Application no: 2025/0922

**Address: Land Adj Tithe Barn Cottages Pendleton Road Wiswell
BB7 9BZ**

**Proposal: Change of use from agricultural building to single
residential self-build dwelling and associated residential
curtilage together with hardstanding/parking.**

Simon Hardie
Highway Development Control Officer

PROPOSED SITE PLAN. SCALE 1:500

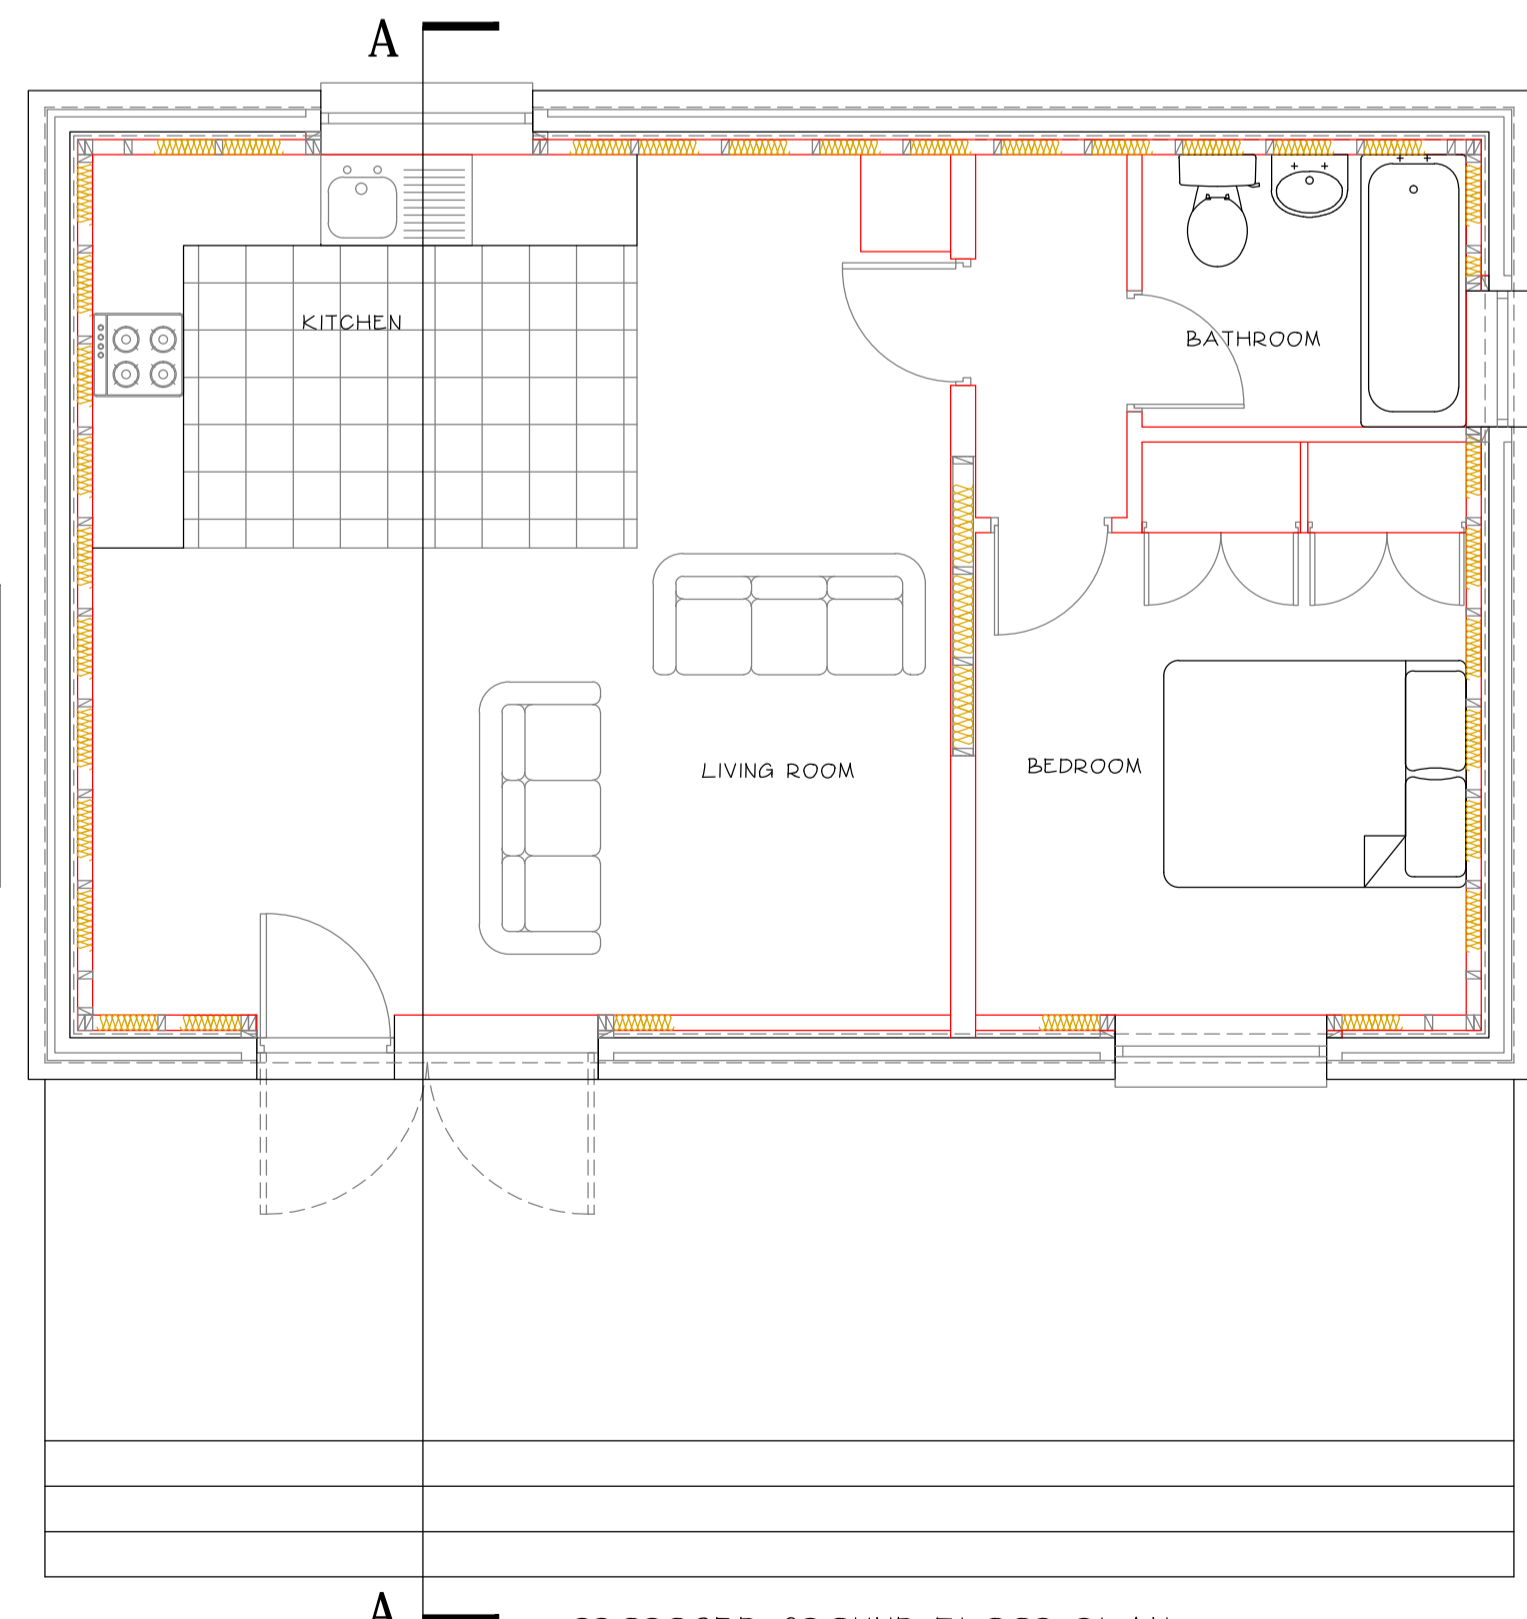
The transport statement refers to the need to cut back the hedge on both sides of the access to ensure that the visibility splay is maintained, currently the splay is not maintained and a condition to ensure that it is viable.

a) Visibility splays.

No building (or use hereby permitted) shall be occupied (or use commenced) until visibility splays 2.4 metres back from the centre line of the access and extending 43m metres on the nearside carriageway edge in both directions have been provided at all accesses/junctions, as shown on the approved plans. Nothing shall be erected, retained, planted and / or allowed to grow at or above a height of 0.9 metres above the nearside carriageway level which would obstruct the visibility splay. The visibility splays shall be maintained free of obstruction at all times thereafter for the lifetime of the development.
